Application for removal or variation of a condition following grant of
 planning permission. Town and Country Planning Act 1990.
 Planning (Listed Buildings and Conservation Areas) Act 1990

Listed Building consent . Proposed remedial work, including re pointing building with lime mortar.

Application reference number:H05-0535-13

The applicant wishes to revise the proposed layout of the scheme to create three apartments in the area currently denoted as unit 12 (postal address Number 12 Holbeach house) .

PROPOSED SECOND FLOOR PLAN

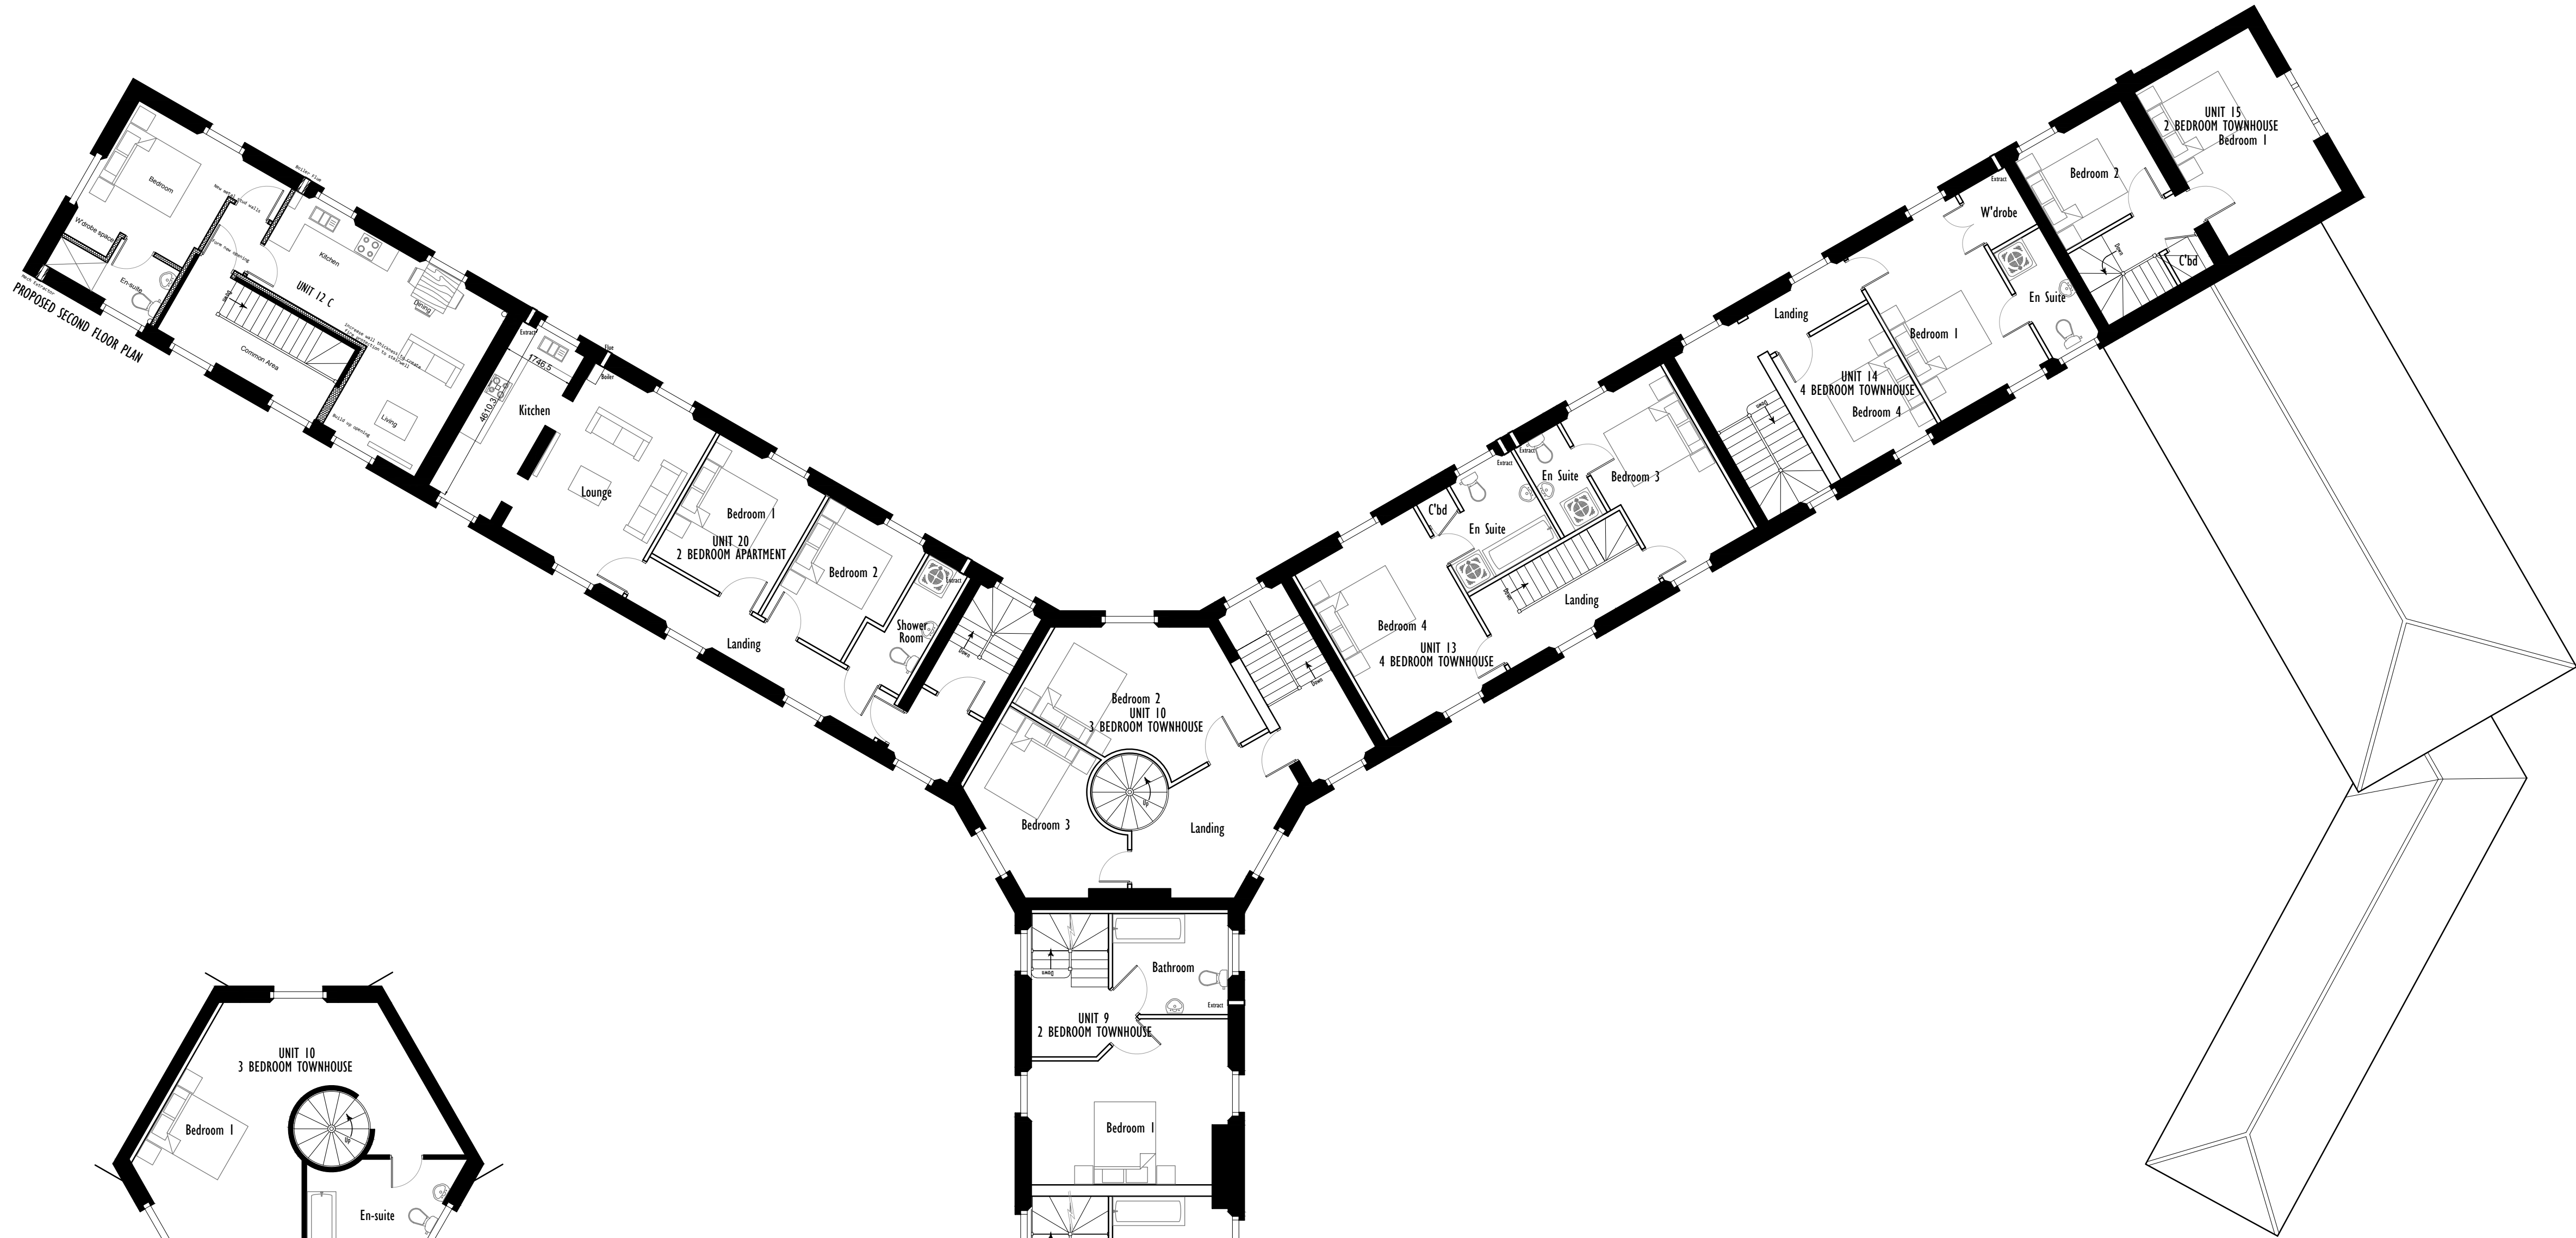
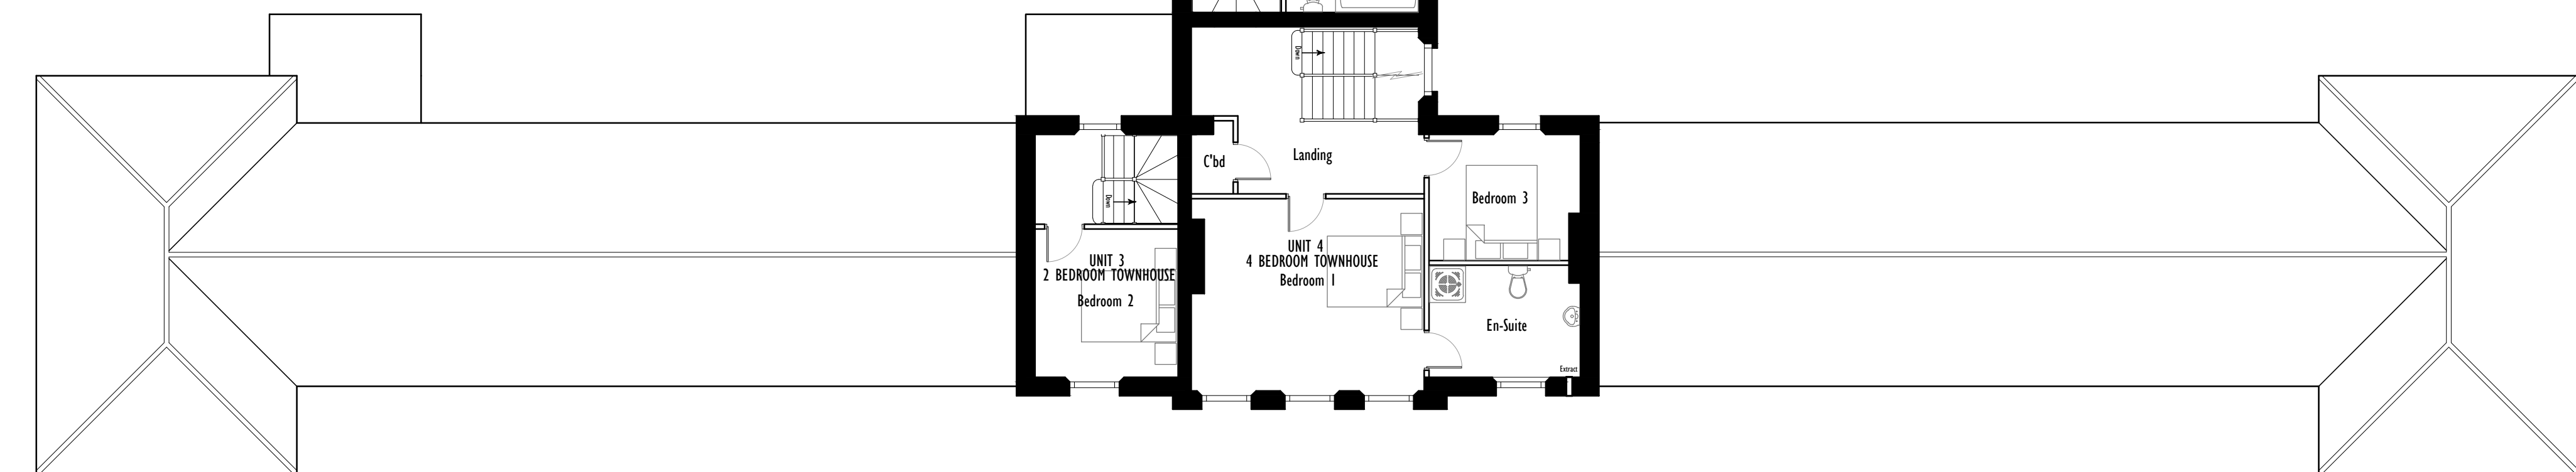
Unit 12 would be revised to incorporate a 1 bedroom apartment on the ground floor, a 1 bedroom apartment on the first floor and a further 1 bedroom apartment on the second floor.

Further Drawing Number IDHH/RW/13/003 to be included in the application.
